From: Laura Gibbons <Laura.Gibbons@arun.gov.uk>
Sent: 22 March 2022 08:37
To: Planning.Responses <Planning.Responses@arun.gov.uk>
Cc: Simon Davis <Simon.Davis@arun.gov.uk>
Subject: RE: Planning Consultation on: BE/176/21/PL

Engineers Further Comments on Surface Water Drainage

Application No: BE/176/21/PL
Registered: 6th December 2021
Site Address: The Cottage Shripney Road Bognor Regis PO22 9PA
Grid Reference: 493805 102331
Category: Plan Applicat'n
Description of Works: Demolition of existing dwelling and ancillary outbuildings and erection of a 66 bedroom care home with associated access, parking and landscaping. This site is in CIL Zone 3 (Zero Rated) as other development & is a Departure from the Development Plan.

Title:
Access Visibility

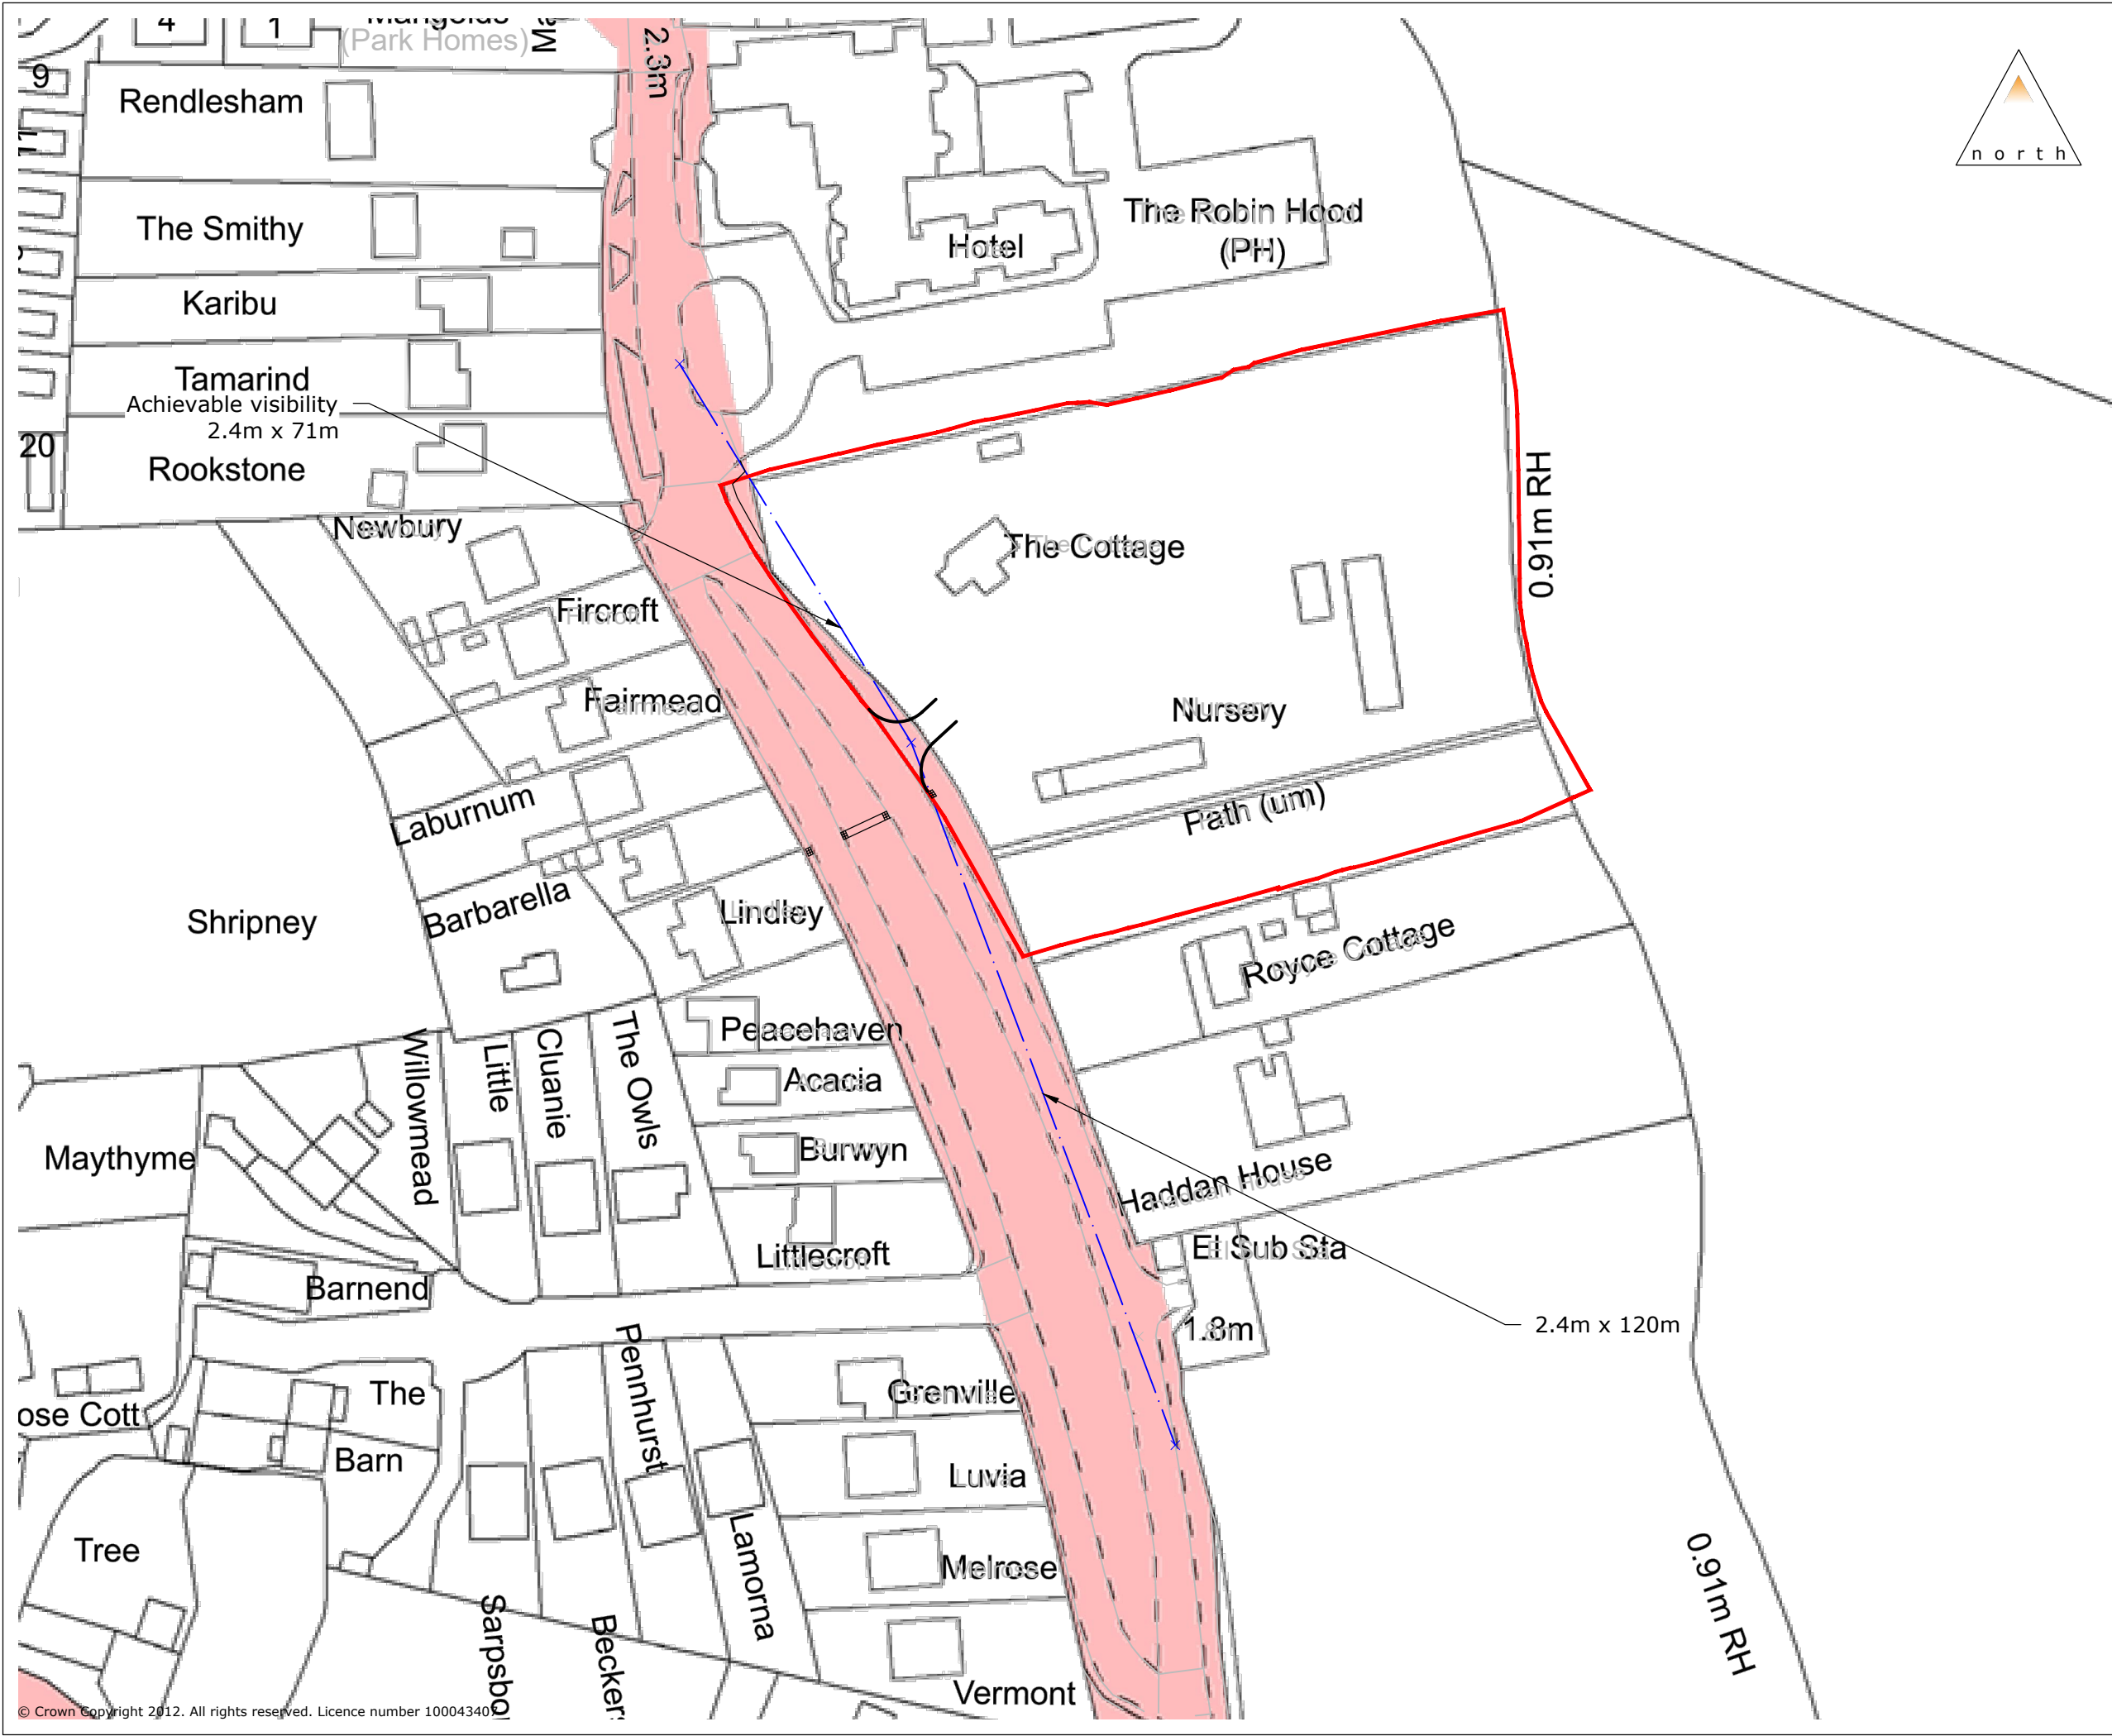
The proposals to culvert a long length of ditch to facilitate the new footpath along Lidsey road do not comply with WSCC culverting policy. We acknowledge that a culvert for the access will be required, but we will not accept proposals to culvert the entire frontage. We expect to see revised proposals for this footpath.
